Our ref: The Gunlake Quarry Continuation Project (SSD-12469087)

Subject: Request for Additional Information

Figure 9 | Groundwater drawdowns and Groundwater Dependent Ecosystem

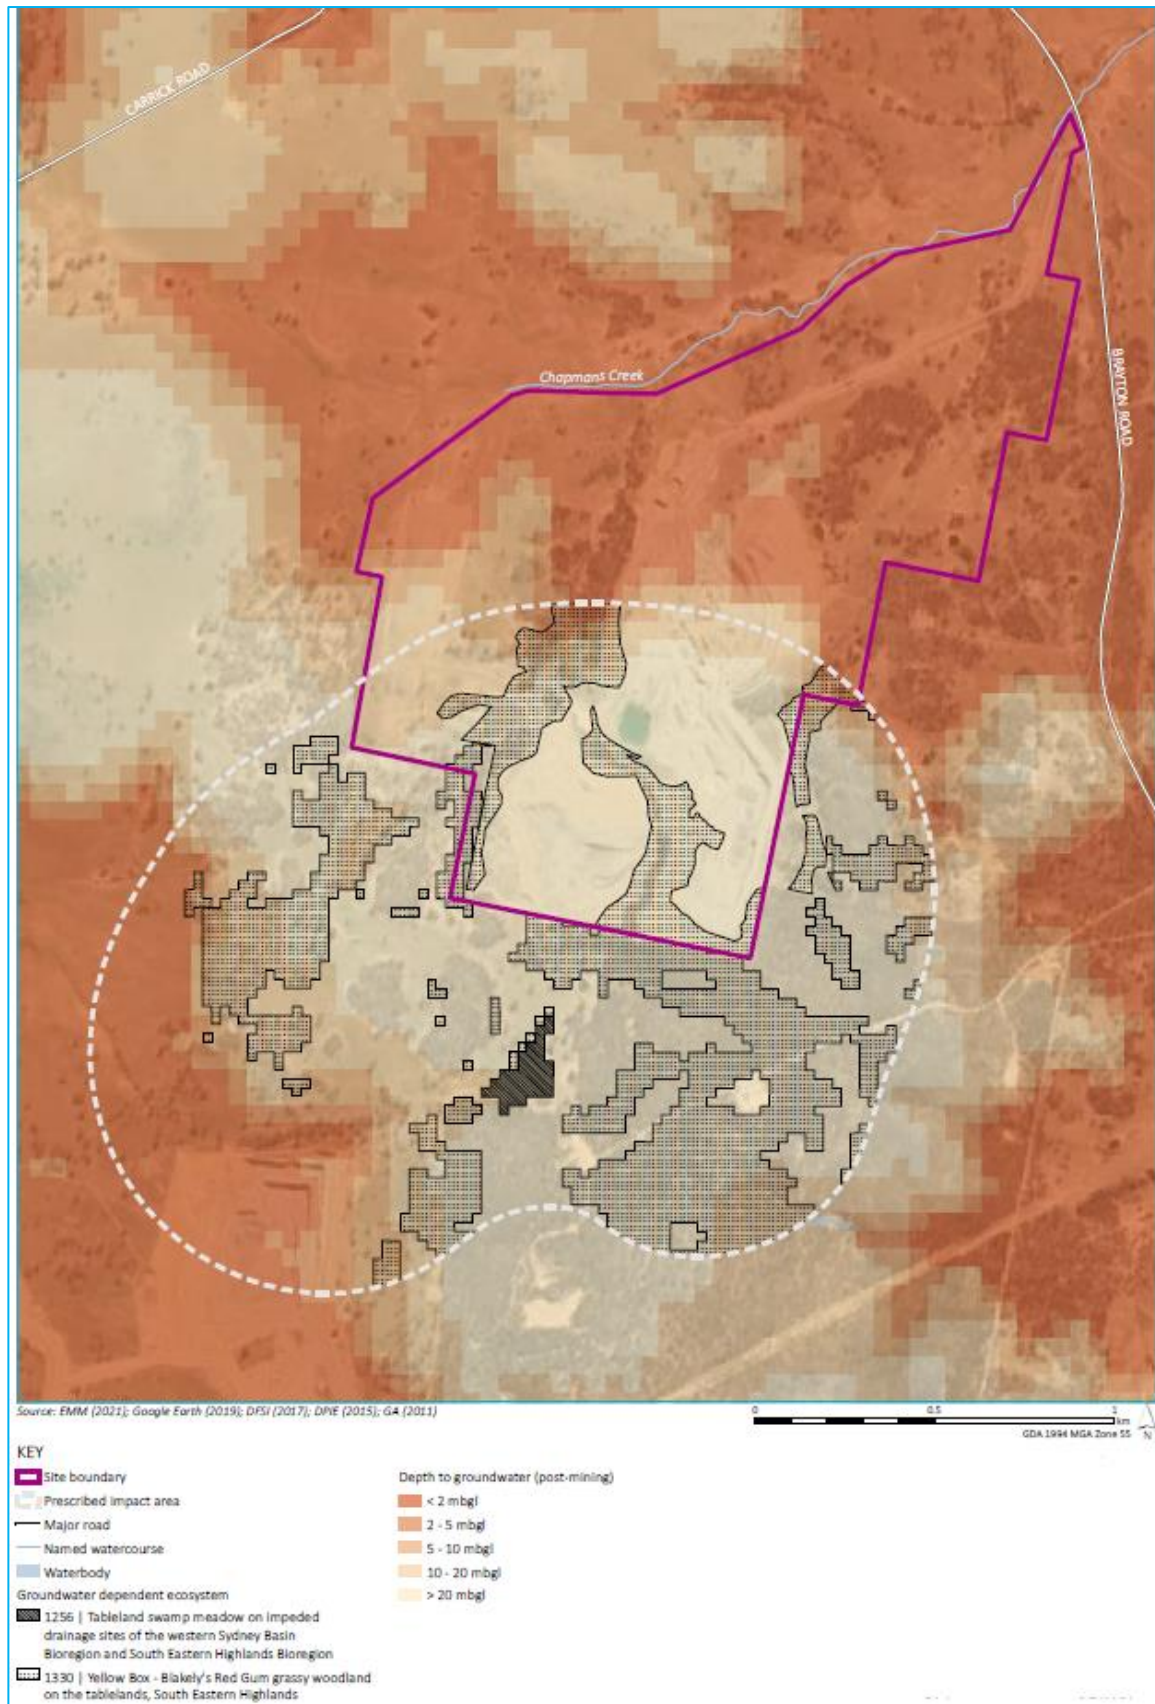
- Figure 3.1: Quarry Site, without the green hatching referred to as Area 1, using the most recent aerial imagery as base map and updated to include the disturbance footprints currently approved for the eastern and western emplacement areas, the quarry pit and the infrastructure area and as shown in the Development Layout figure in Appendix 1 of the consent SSD-7090; and
- Figure 6.2: Groundwater drawdowns and GDEs, without the mapped PCT 1256 vegetation community.
